TO	Nicole Brewer, Director, Energy Assessments
FROM	Mark Davey
DATE	17 July 2026
OUR REFERENCE	0617753
SUBJECT	Keri Keri Wind Farm (SSD-3858962) Request for Additional Information

Keri Keri Wind Farm (SSD-3858962)–Request for Additional Information

Ref No	Theme	Submission	Response	Where Addressed
TfNSW-01	Traffic (generation)	1. Preconstruction Minor Works for workers accommodation camp traffic assessment requirements. A complete assessment of the wind farms and workers' accommodation camp construction pre-construction minor works is required and is to include: - Assessment of traffic volumes and identification of the types of vehicles that will be used during this period, including the largest design vehicle. - Perform a swept path analysis for the largest heavy vehicle at the existing intersection, ensuring it can navigate within the current pavement. If the design vehicle cannot turn easily, implement necessary mitigation or temporary works. - Assess existing Safe Intersection Sight Distance (SISD) and propose measures to achieve compliance, - Identify AM/PM peak hour traffic volumes and proposed volumes during this time. Traffic volumes during the AM/PM peak hours are to be c

Keri Keri Wind Farm - OSOM Routes 1A/1B
 KM Index 2.7: Sturt Highway / Murray Valley Highway, Euston
 Strategic Concept Design

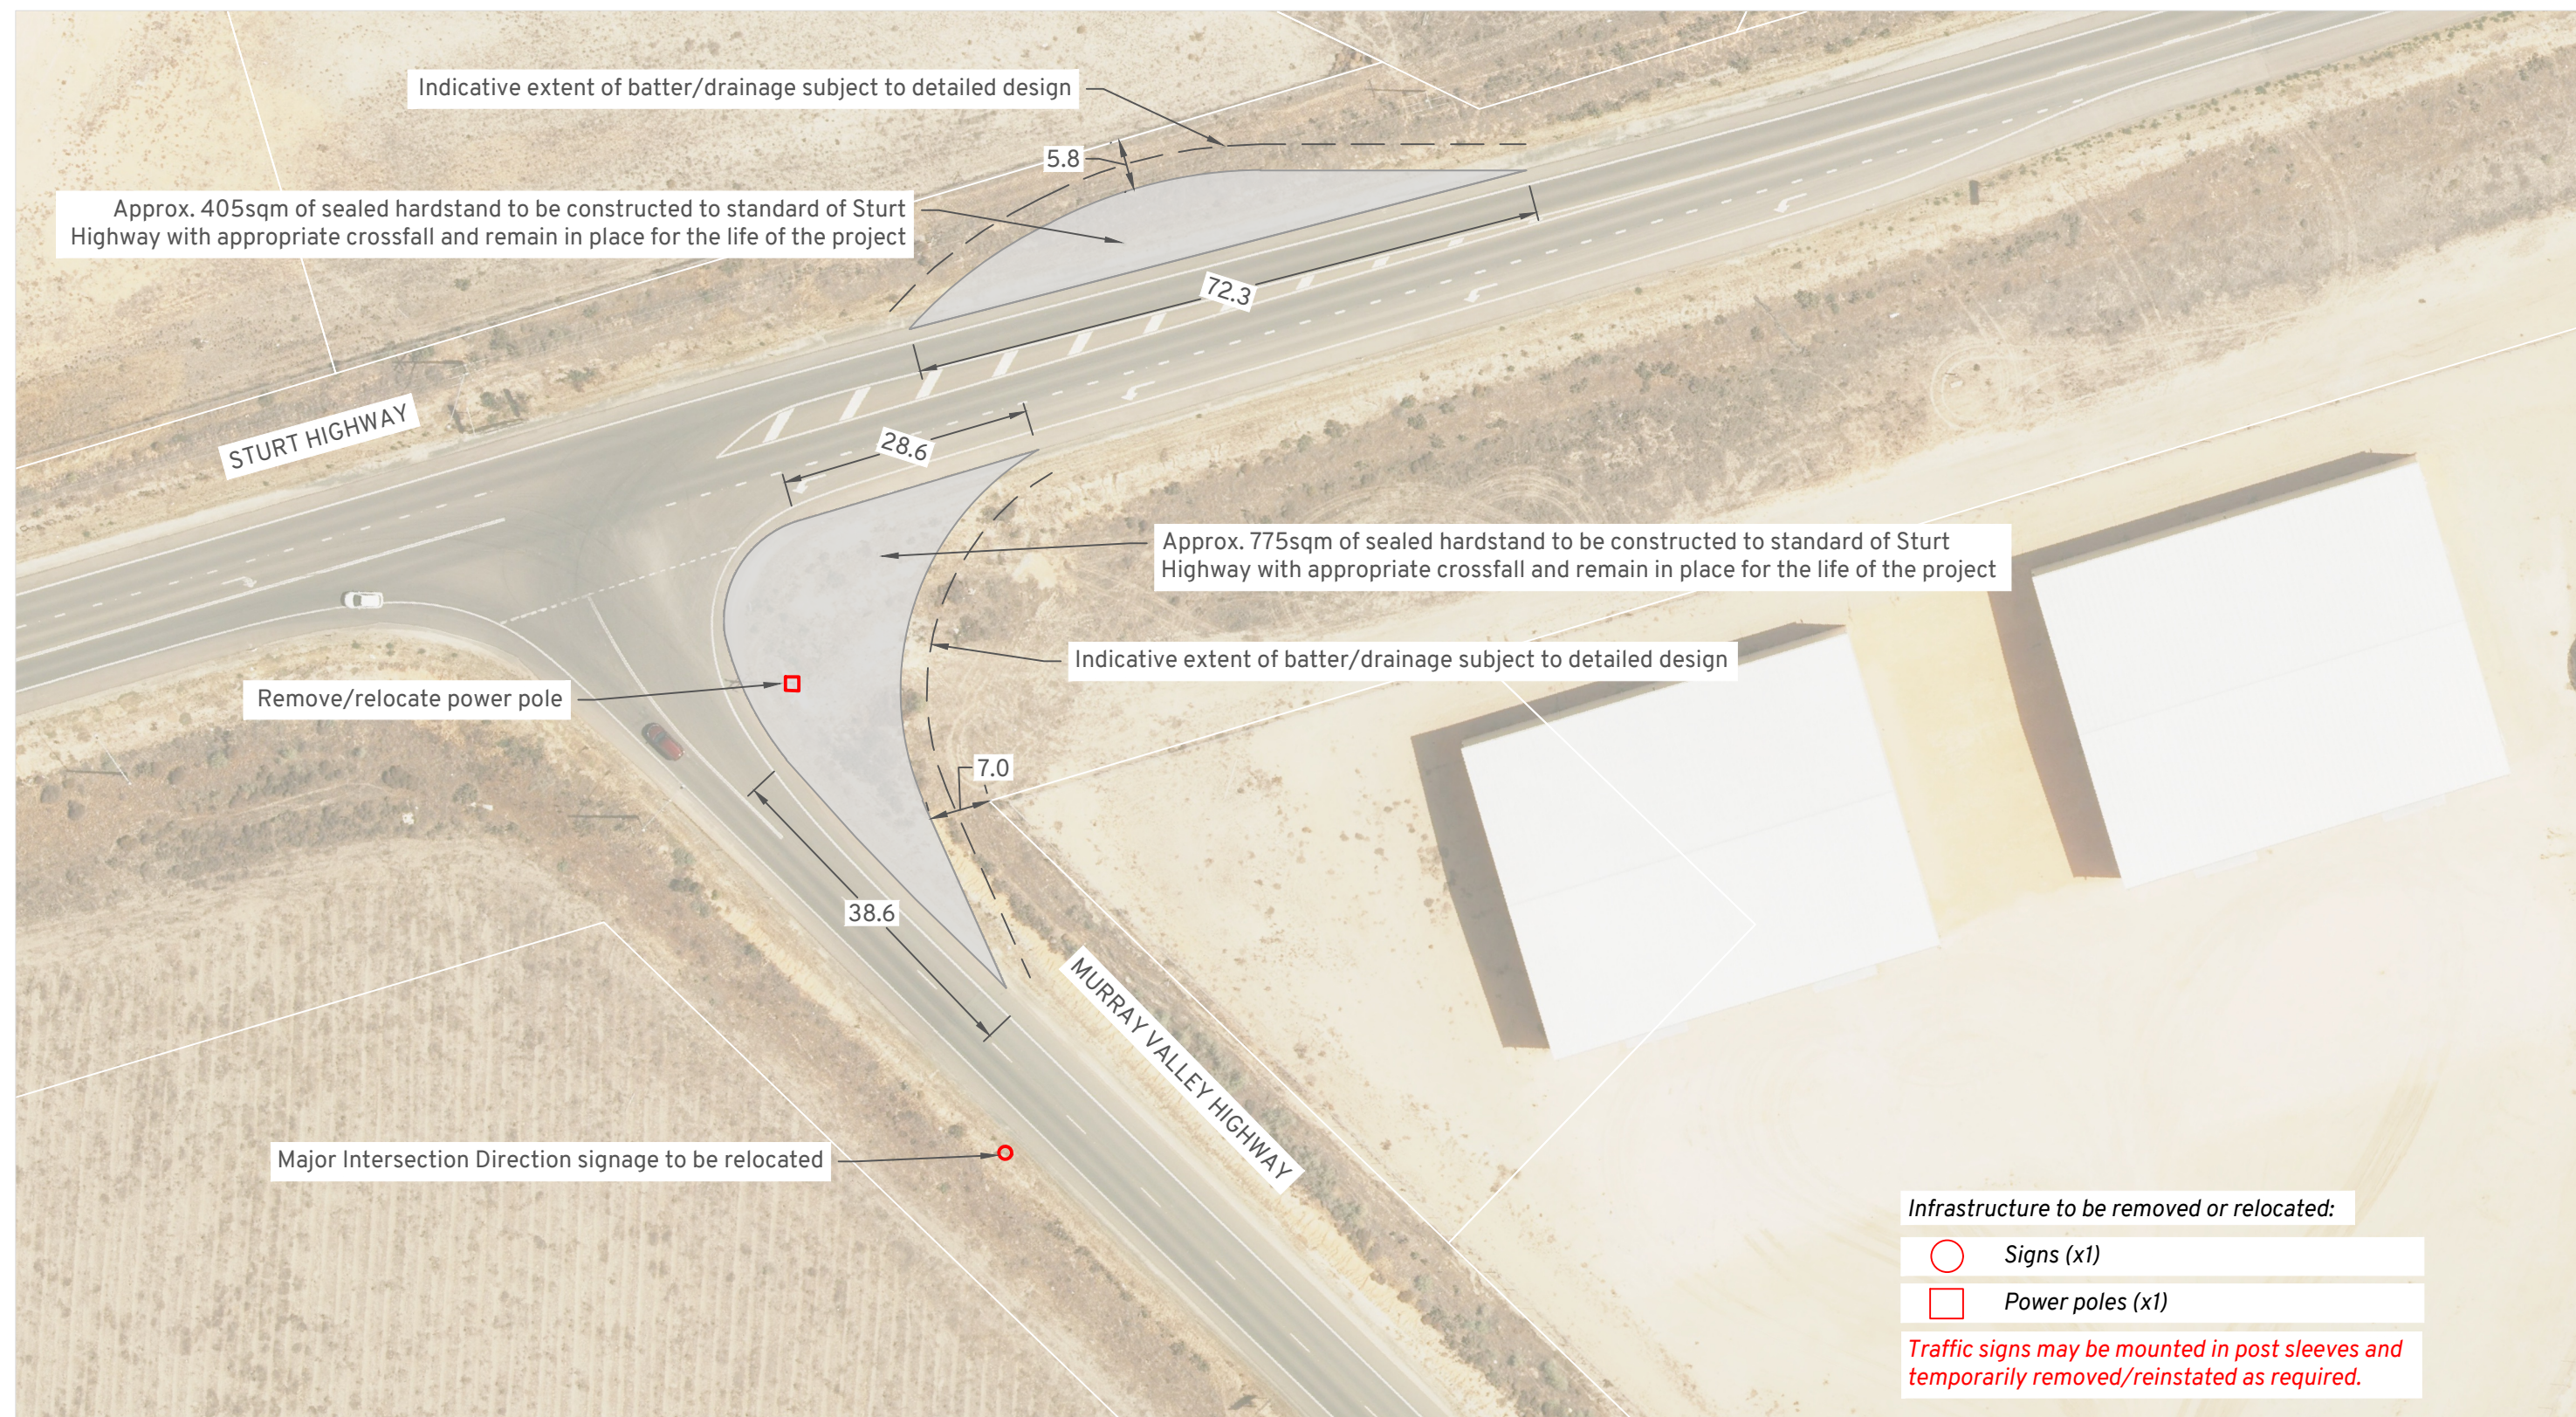
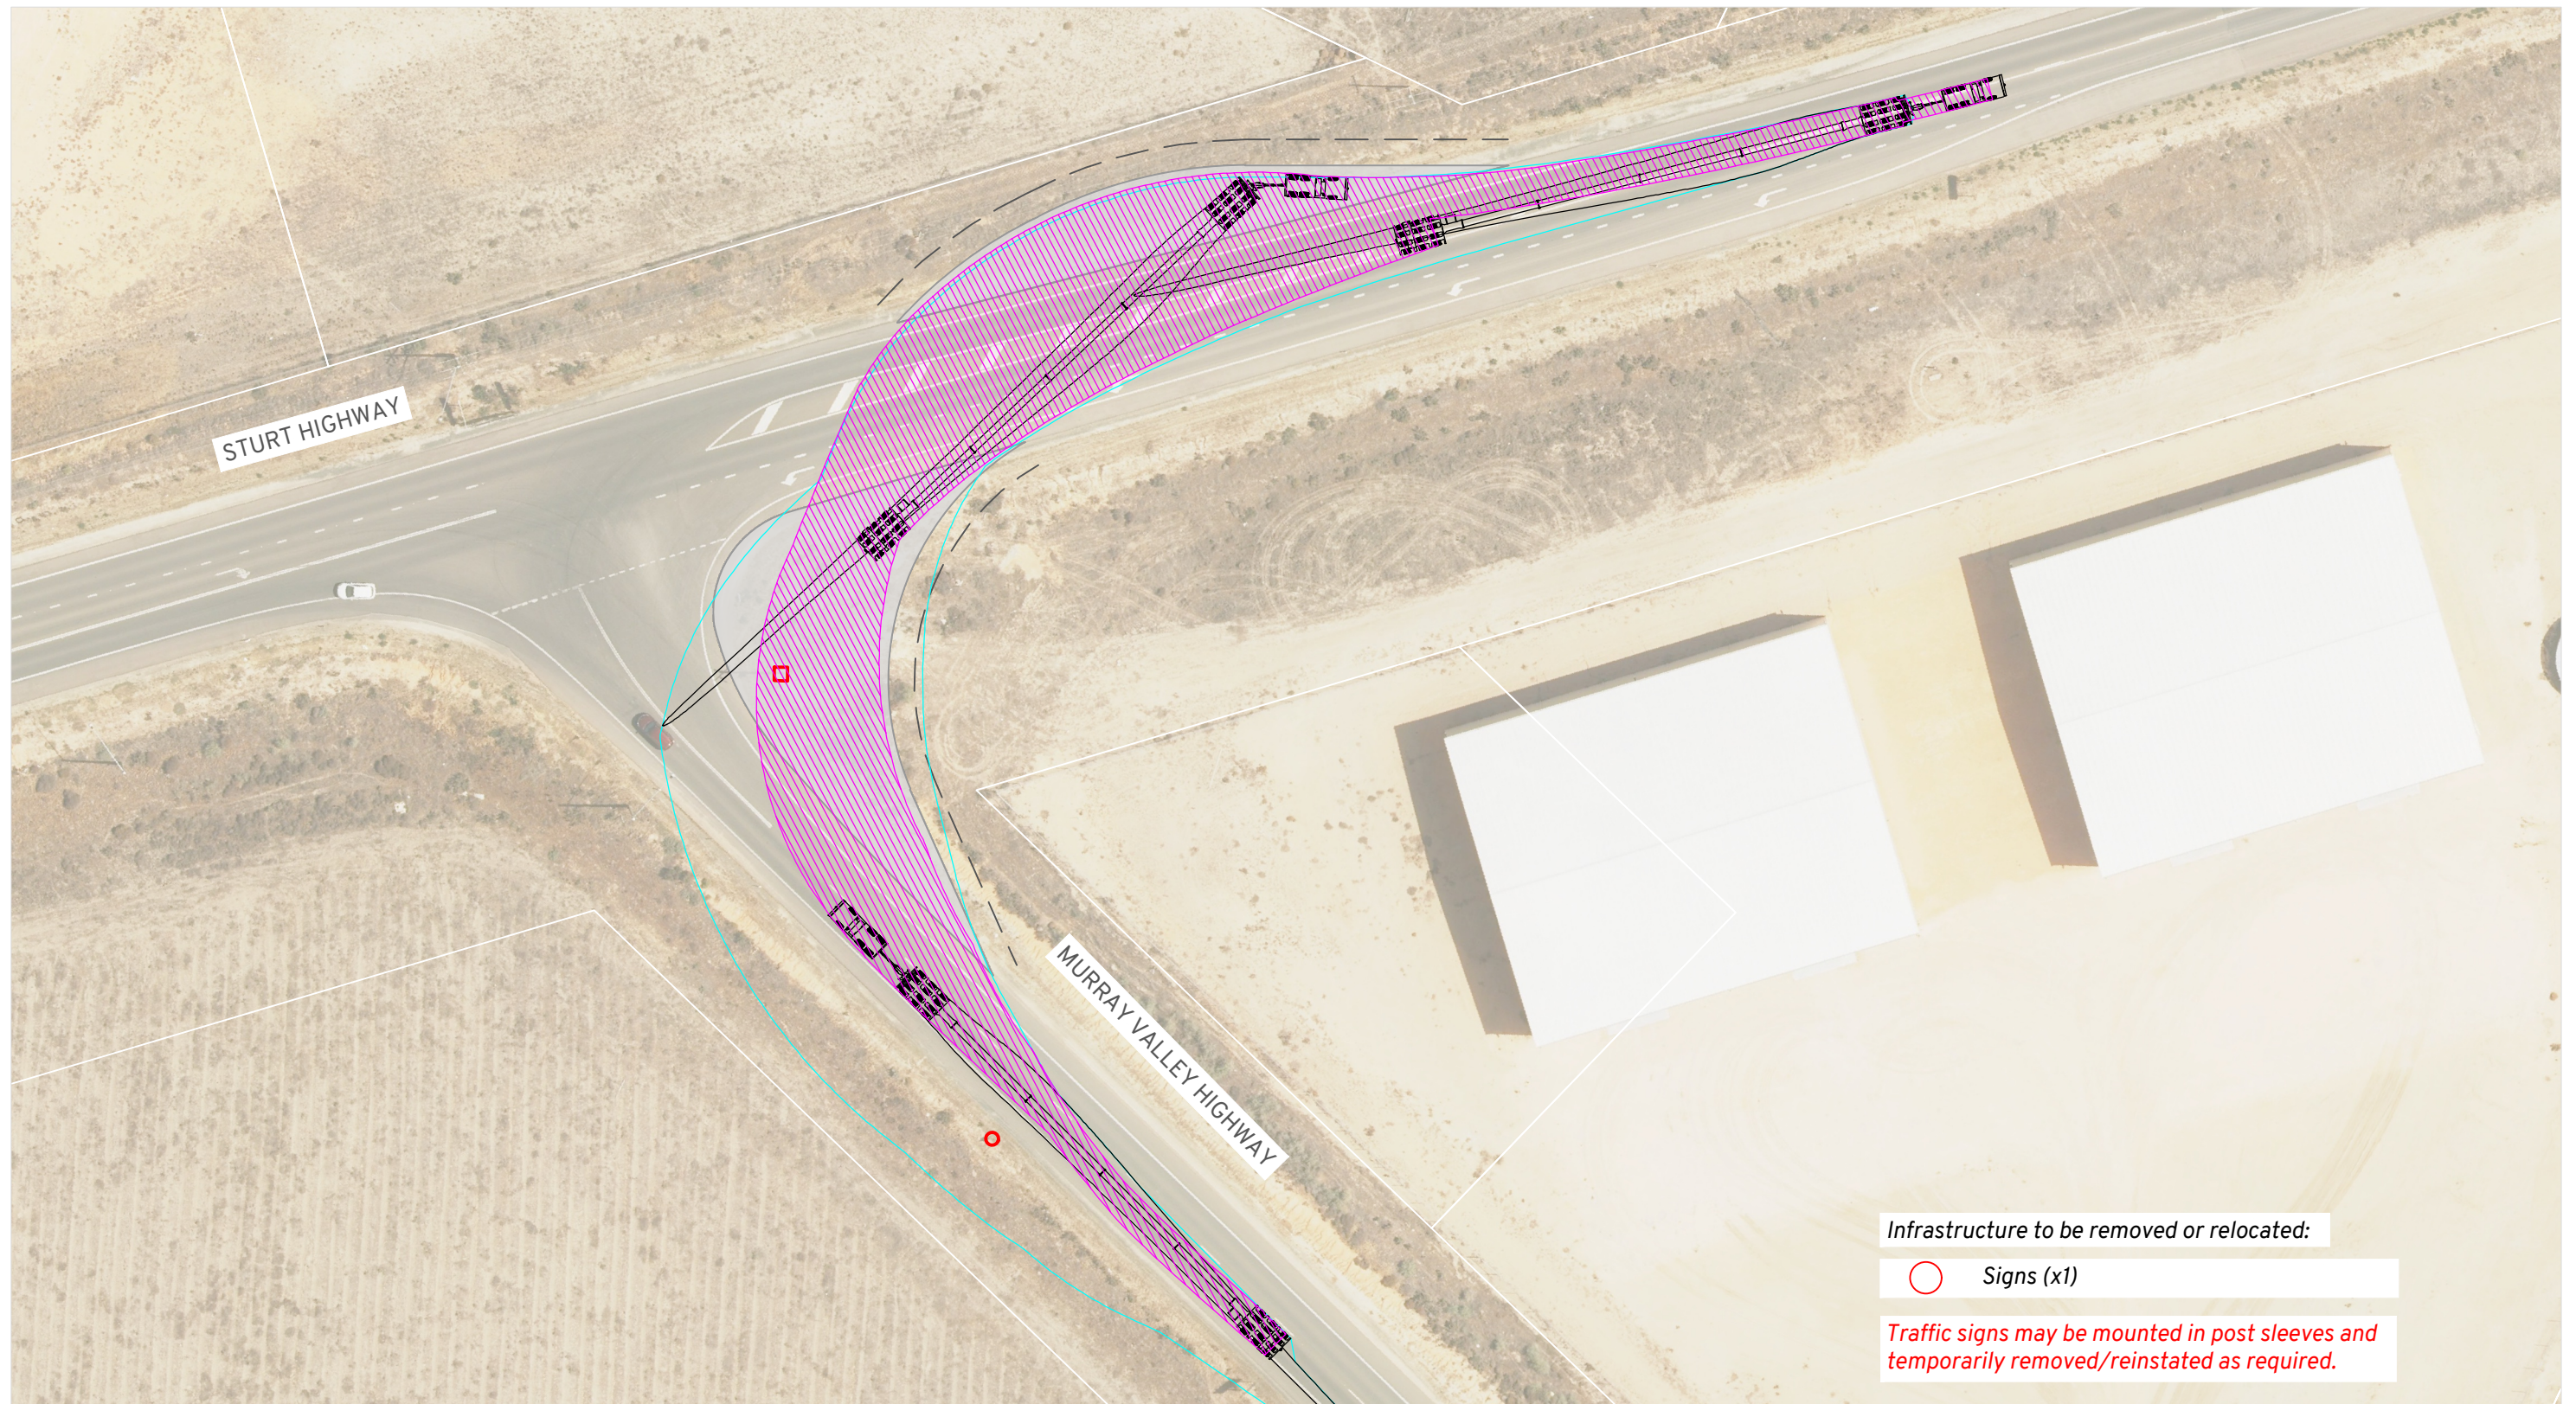
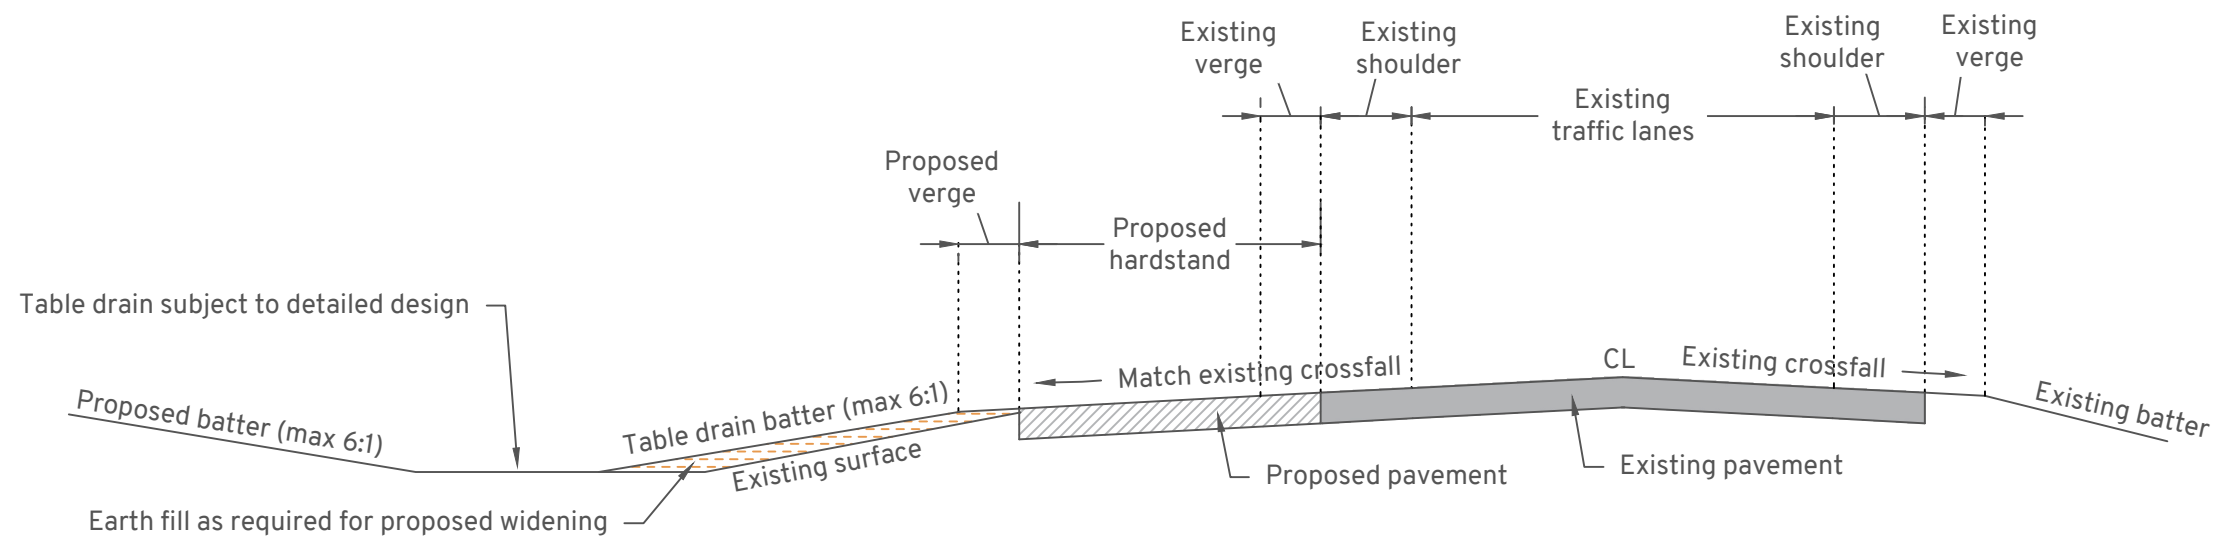
TfNSW-03	Strategic Designs	a. Revision D Civil Design, RJ Andrews SPA - Murray Valley Hwy onto Sturt Highway - The existing fill embankment is high, with swept paths showing to track close to cadastre boundaries. Hardstand areas will need to be quantified to determine the scope and footprint of the fill required for the embankment and to confirm whether land acquisition is required. b. Revision D Civil Design, RJ Andrews SPA - Murray Valley Hwy onto Sturt Highway - There appear to be numerous underground utilities located on the south-east corner of the intersection. Further investigation required to determine the level of impact.	Revised strategic concept design for this intersection is provided in Appendix A (Sheets 01-03). The vehicle swept path and hardstand areas have been adjusted to provide additional clearance to the adjacent property boundaries for embankments/batters and drainage which would be determined during detailed design. Underground utilities would also be confirmed as part of the detailed design process. Furthermore, it is understood that EnergyCo is in the planning stages for the South-West REZ and high-level strategic designs have been prepared for this intersection to accommodate OSOM movements. TfNSW is progressing the intersection upgrade through concept and detailed design stage.	Appendix A (sheets 01-03) of the Amended TIA (Attachment D)

i. Revision D Civil Design - 21012CAD003 Figure 2 - The existing fill embankment is high, with swept paths showing to track close to the cadastre boundaries. Hardstand areas will need to be modelled as part of the strategic concept designs to be revised prior to determination, to quantify the fill embankment and confirm the exact scope of the road works, and to determine whether acquisitions are required. - There appear to be numerous underground utilities located on the southeast corner of the intersection. Further investigation required to determine the level of impact.	Revised strategic concept design for this intersection is provided in Appendix A (Sheets 01-03). The vehicle swept path and hardstand areas have been adjusted to provide additional clearance to the adjacent property boundaries for embankments/batters and drainage which would be determined during detailed design. Underground utilities would also be confirmed as part of the detailed design process. Furthermore, it is understood that EnergyCo is in the planning stages for the South-West REZ and high-level strategic designs have been prepared for this intersection to accommodate OSOM movements. TfNSW is progressing the intersection upgrade through concept and detailed design stage.	Appendix A (sheets 01-03) of the Amended TIA (Attachment D)
